23 November, 2010

RE: PROPOSED PREFORM INJECTION MOULDING PLANT **COCA COLA AMATIL SITE, EASTERN CREEK**

1. As requested, we are writing regarding traffic and parking matters raised by the Department of Planning in relation to the above development. We have previously prepared a report⁽¹⁾ which was submitted with the Part 3A application.
2. The traffic and parking matters raised in submissions, and our responses to these matters, are set out below.

DATE	26-07-10	PROJECT No.	STATUS
SCALE	1:250	(B)	1026
DRAWN	JTC		AR/DA
CHECKED		DWG No.	
APPROVED		DA 05	/C

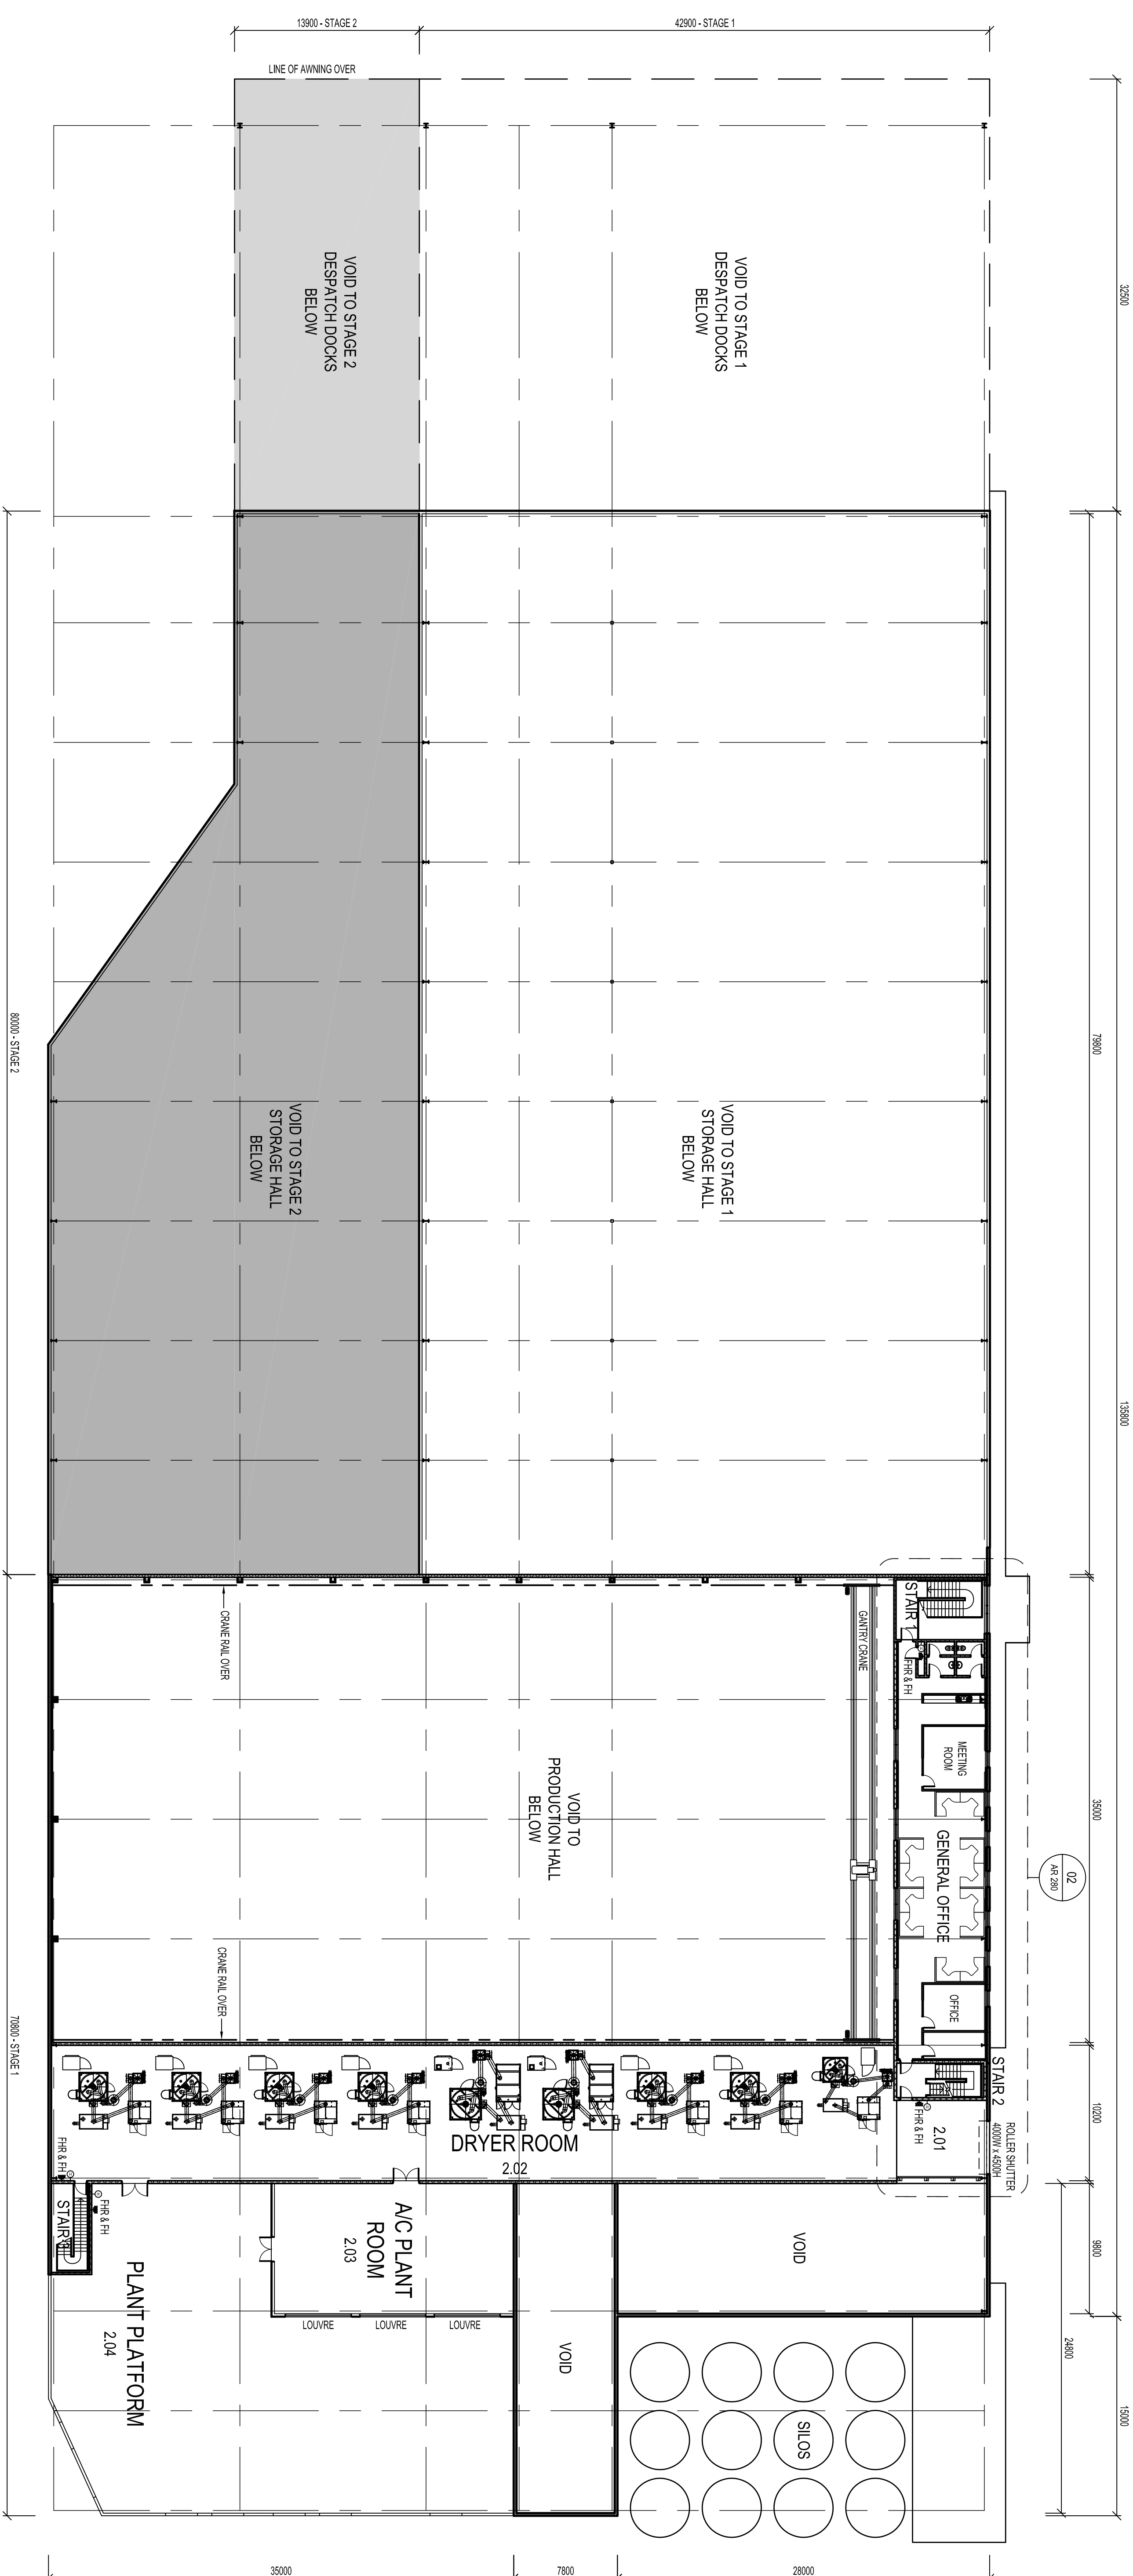
- ***P14 of the traffic assessment states 'the site access arrangements remain unchanged' yet p12 of the EA states there will be 'minor reconfiguration of vehicle access arrangements at the southern end of truck entry'; p2 of the waste assessment also states that there will be a reconfiguration of the existing access arrangements. Please clarify.***

13. The minor reconfiguration of the vehicle access arrangements, as described on p12 of the EA report, refers to changes to traffic circulation at the southern end of the internal access road, located adjacent to the eastern boundary of the site, as shown on Figure 1. The proposed changes include a shortening of the central median/vehicle separation, in order to provide for vehicle swept paths and access to future loading docks. Access arrangements at the access driveway onto Roussell Road will remain unchanged.
